**PUBLIC WORKS DEPARTMENT**

May 15, 2024

Re: Undi Commerce Park – *Concurrency Recommendation*  
PA 22008

Conceptual Midblock Crossing Layout

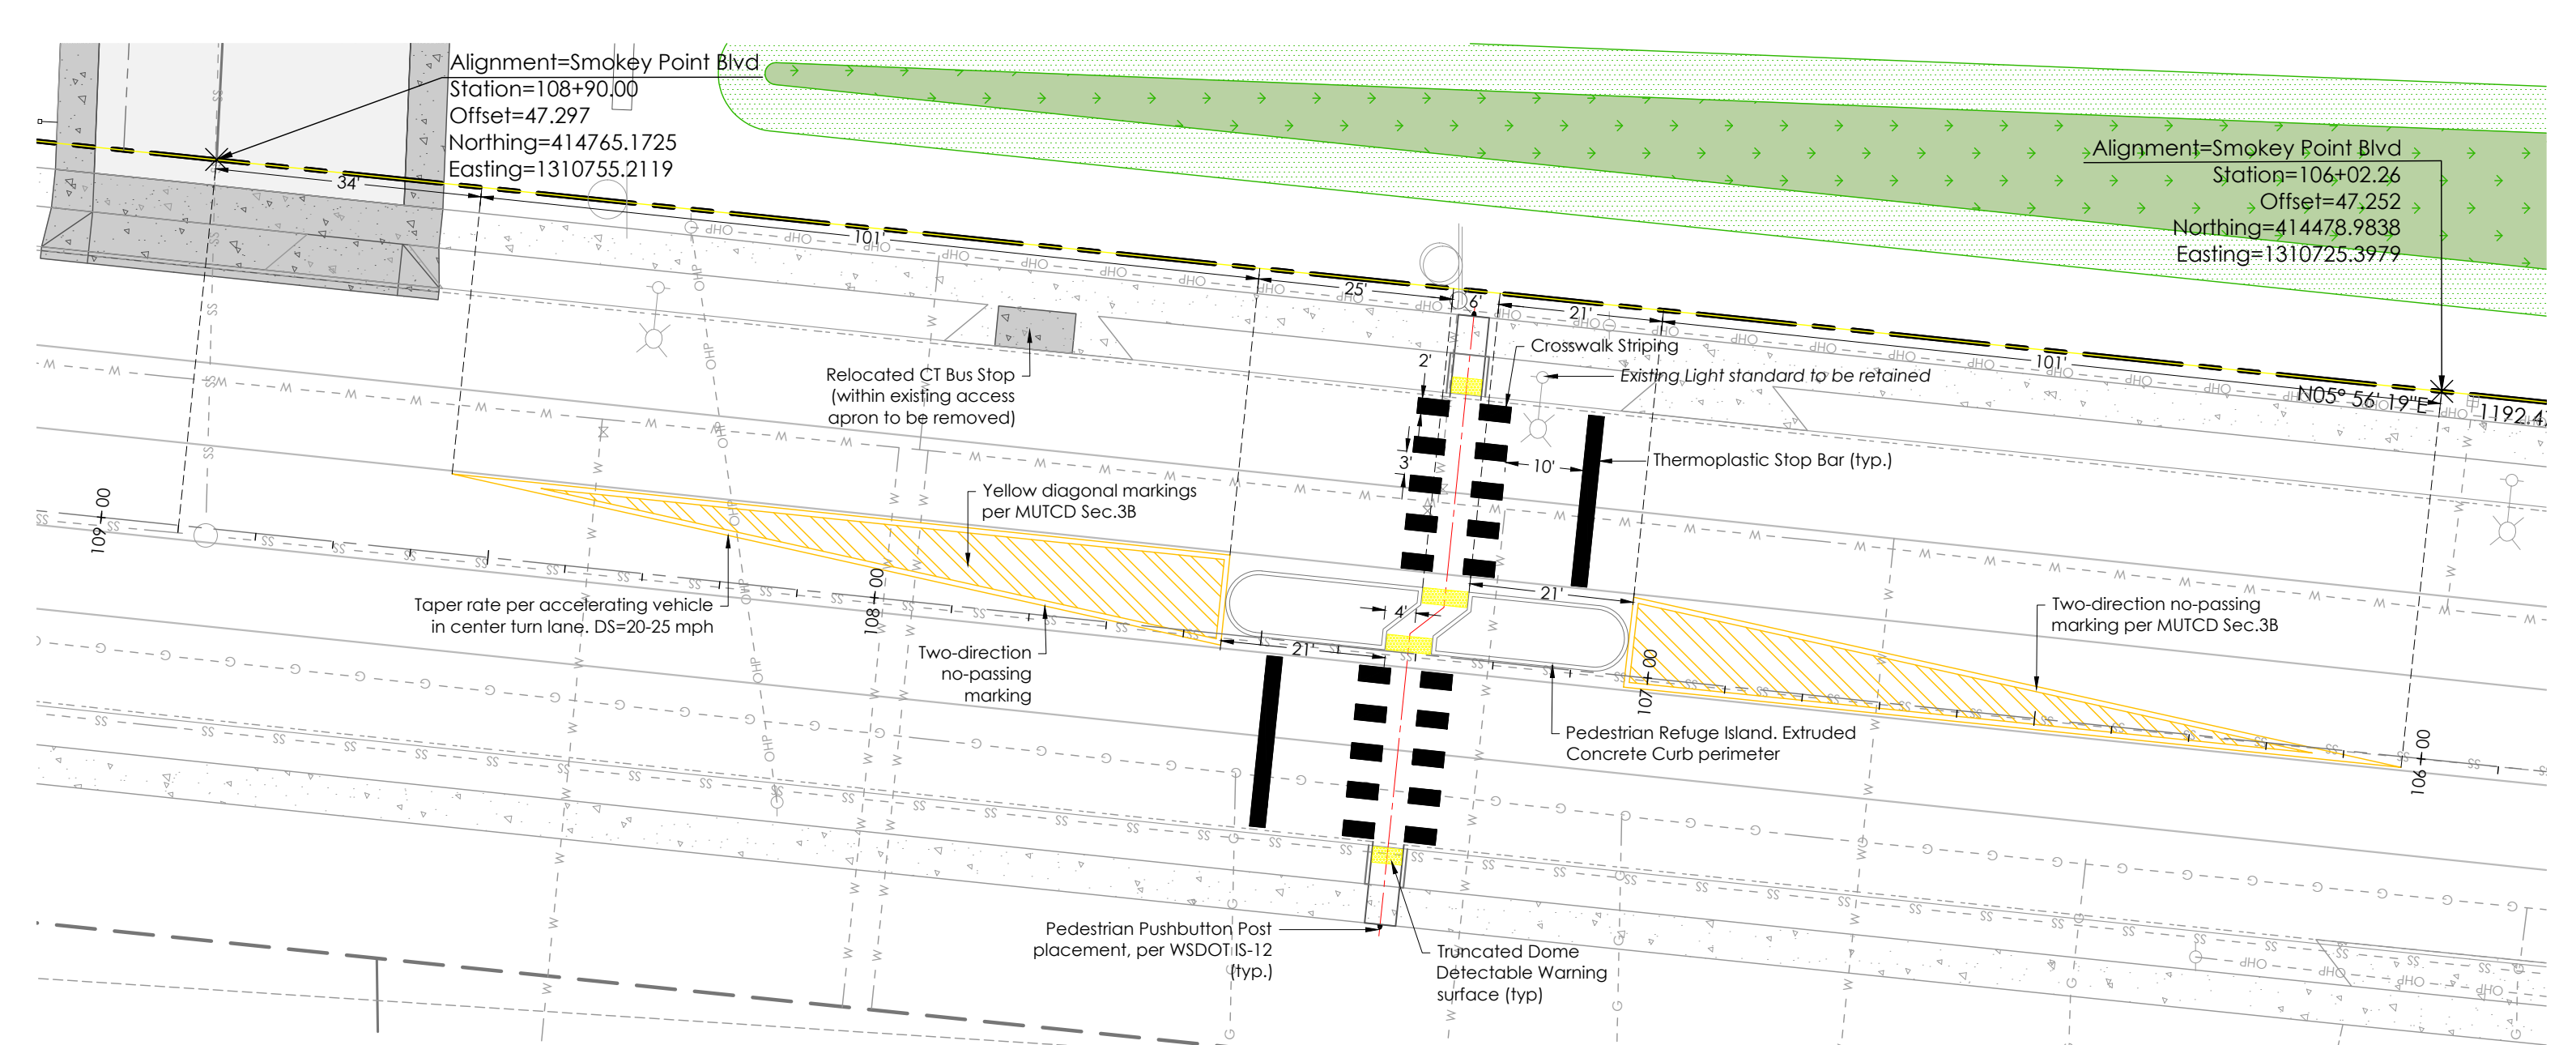
4. Due to the proximity of the proposed joint use driveway and the existing span wire Emergency Fire Signal and crosswalk located on Smokey Point Boulevard, the applicant shall be required to construct the following improvements:

- 4.1 Reconfiguration of the span wire signal heads to provide for Emergency Fire Signal operations, only.
  - 4.2 Relocating the existing pedestrian crosswalk contained within the traffic signal operations to the north or south with installation of a marked two-stage offset mid-block crosswalk with Rectangular Rapid Flashing Beacons (RRFB) systems. Fully built-out Pedestrian Median Refuge Island will be required with pedestrians having a 2-state RRFB system with a non-direct through pedestrian path to encourage viewing of oncoming traffic.

- 4.3 Community Transit Bus Stops on both east and west side of Smokey Point Boulevard will need to be relocated to be near relocated crosswalk, or as approved by Community Transit.

**Frontage Modification Plan**

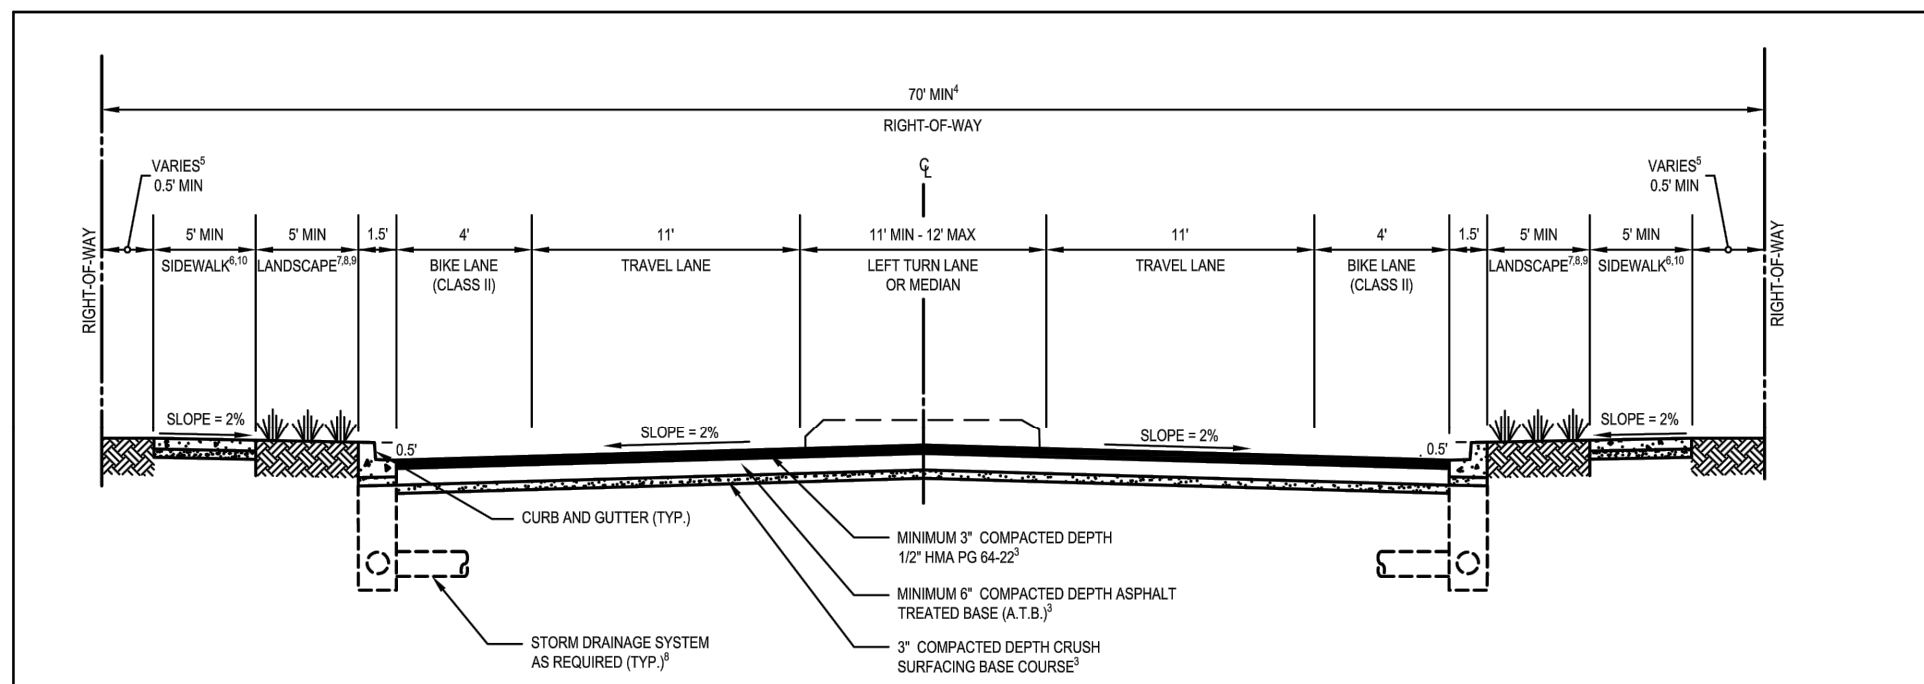
2. The applicant shall be required to construct frontage improvements along Smokey Pont Boulevard for the proposed vehicular access points to the site and remove and replace frontage improvements for any current access points. Roadway improvements, channelization, site access and lighting plans shall be required to be reviewed and approved by the City Engineer, prior to construction plan approval.
